City of Albuquerque Stormwater Construction Site Inspection Report

General Information					
ESC File No.	M09E032	Project Name:	Sombra del Oeste		
NPDES Id. No.	NMR1005WH	Location:	Gibson Blvd and Valley Cottonwood SW		
12/18/2024	Owner		Contractor		
Operator	Homewise Inc.				
Contact name & title	Eugene Chavez				
e-mail	echavez@homewise.org				
Contact Phone #	505-983-9473				
COA Inspector	James Hughes		Start/End Time:	10am	
Construction Phase:	Earthwork and Utilities.				
Type of Inspection:	<input checked="" type="checkbox"/> Regular	<input type="checkbox"/> Storm Event	<input type="checkbox"/> Post Storm Event >0.25"	<input type="checkbox"/> 311/Complaint	<input type="checkbox"/> Follow Up
Weather at time of inspection?		Clear		Temperature: ~	45
Estimated date of last storm 0.25" or greater		11/7/2024

**(A1) DRAINAGE PLAN
PROPOSED CONDITIONS**
1" = 30'-0"

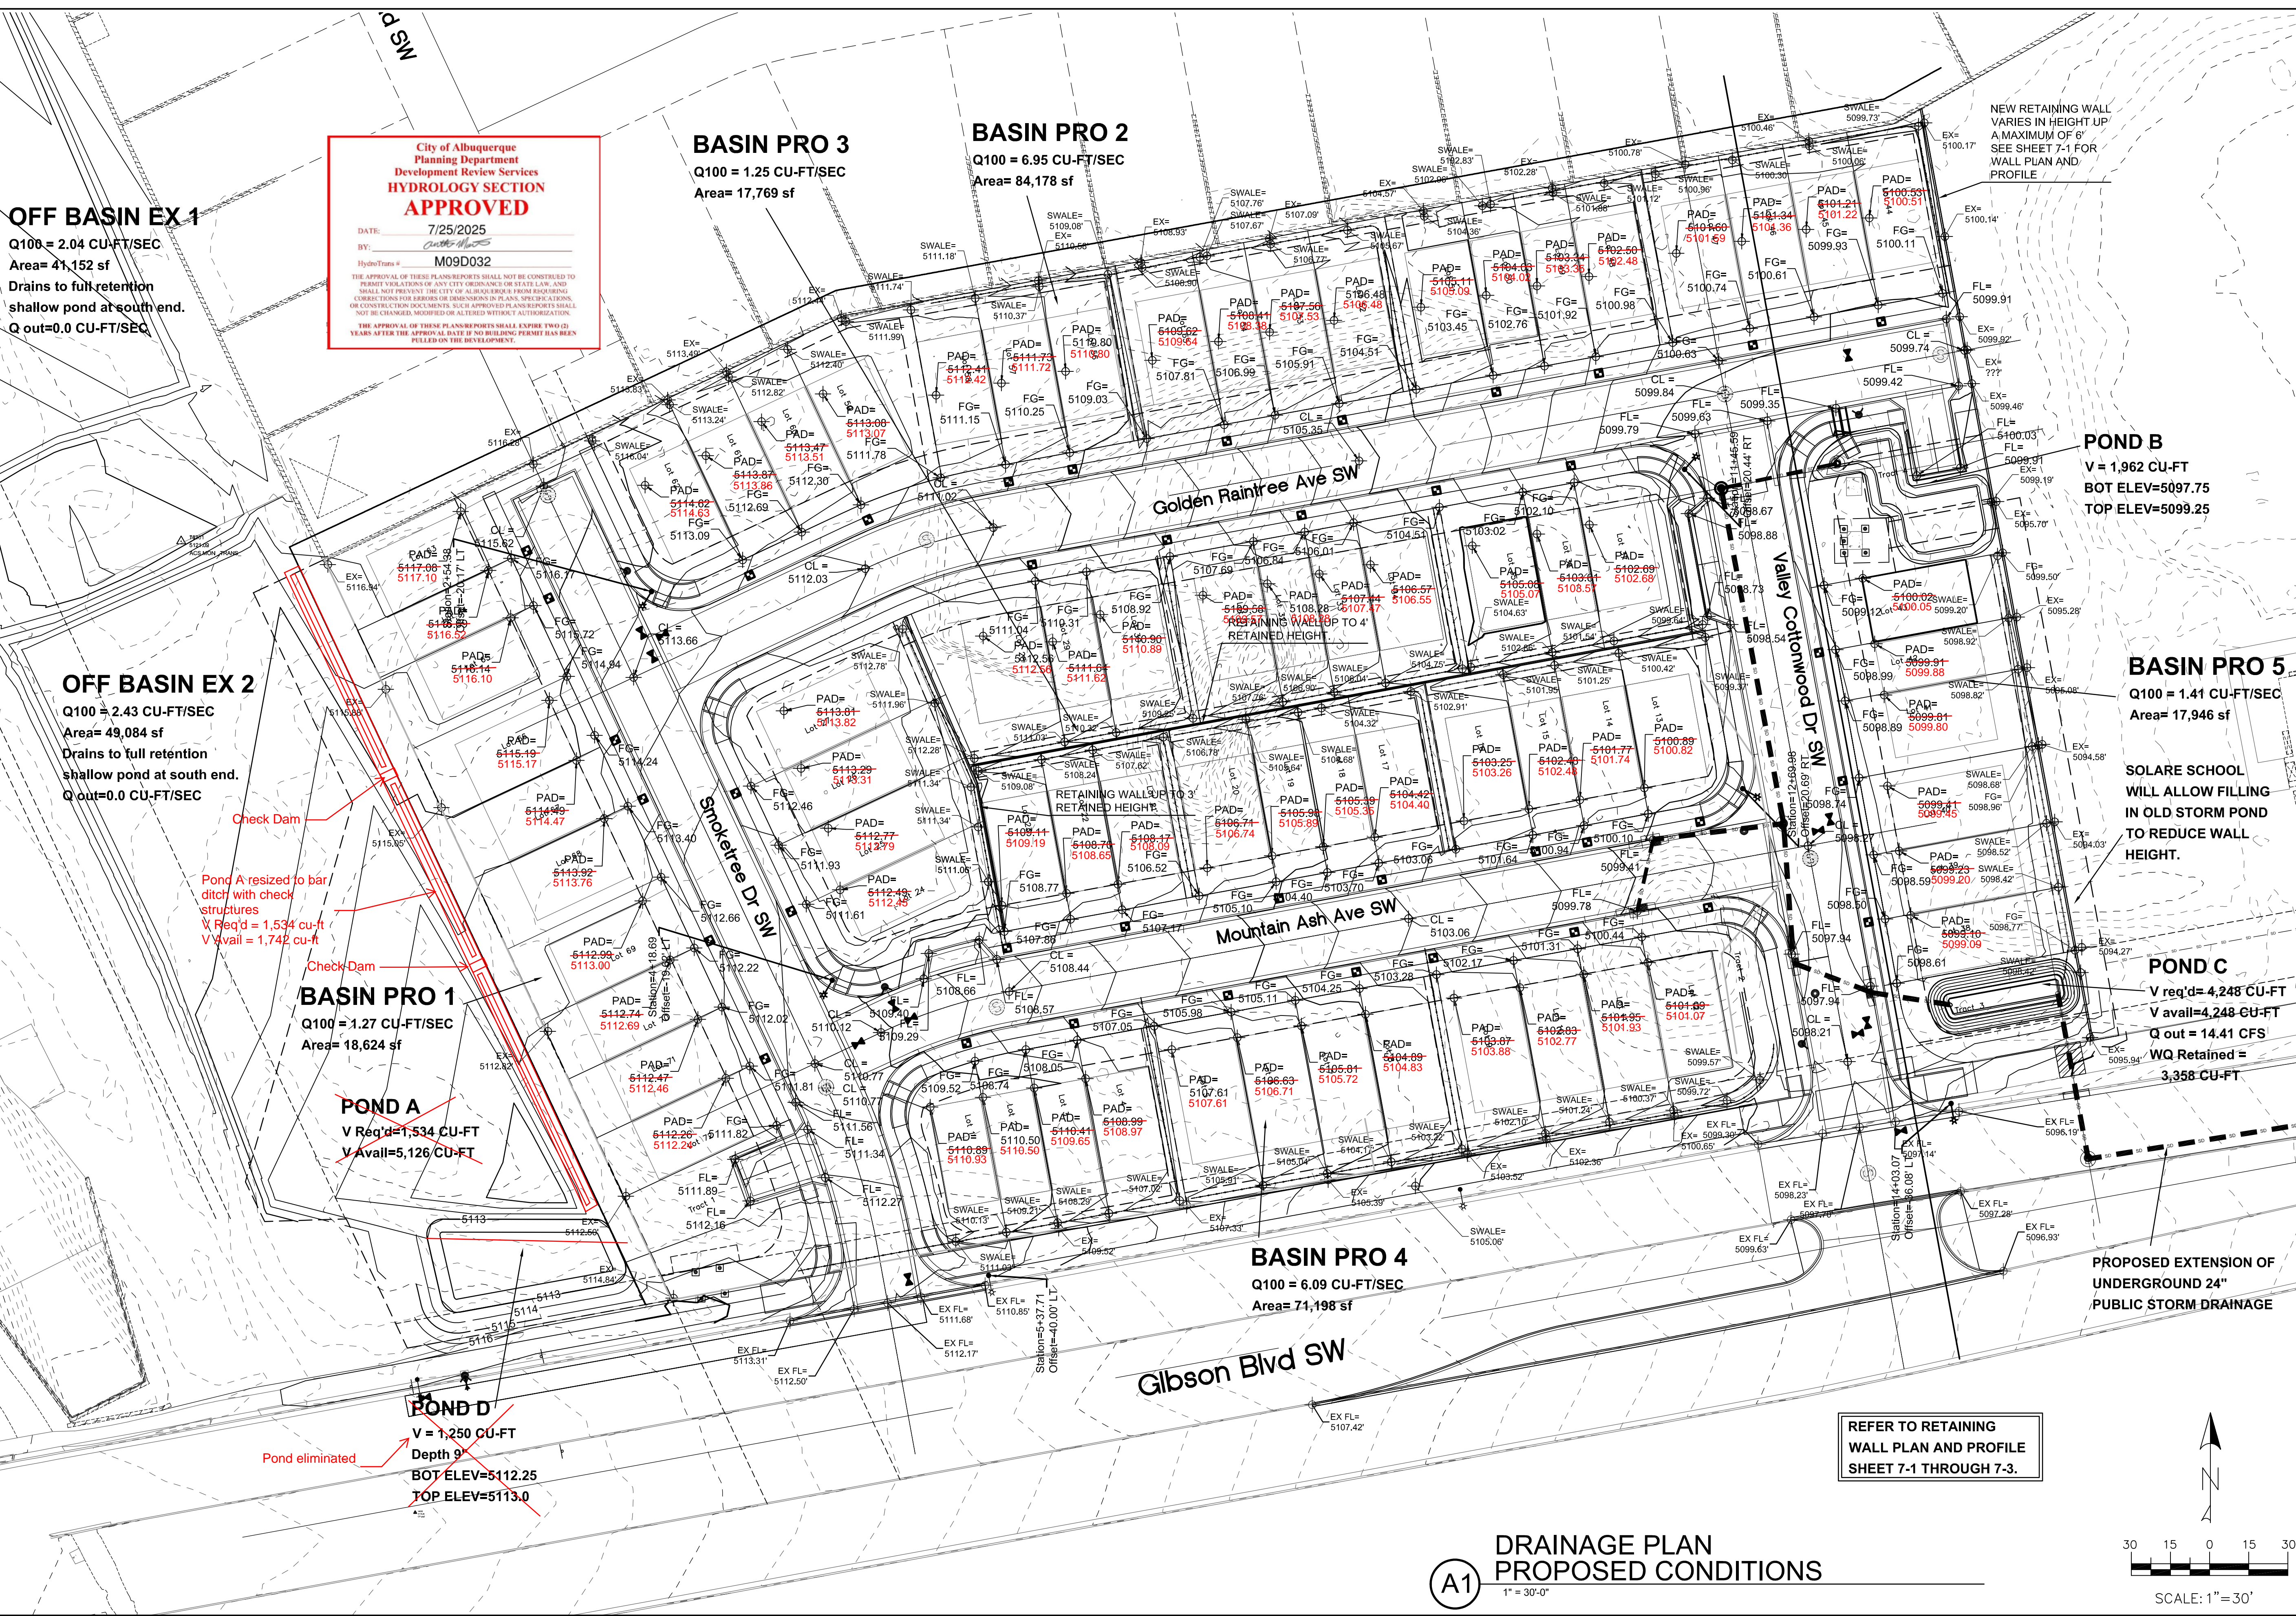
2.1	Discharge off site? (Y/N)	Yes			
4	Self Inspection Reports	missing	Latest report Date:	missing	
Notes: Pad and Street subgrades were complete, but Ponds B&C were missing.					
The site drained to two concentrate discharge points on the east side of the site, where the only BMP was a few feet of SF. This site cannot discharge any surface drainage. The only allowable discharge is into a city storm drain, and only that portion in excess of the 2-ry-24-hr runoff volume. This site must retain the 2-yr 24-yr volume onsite.
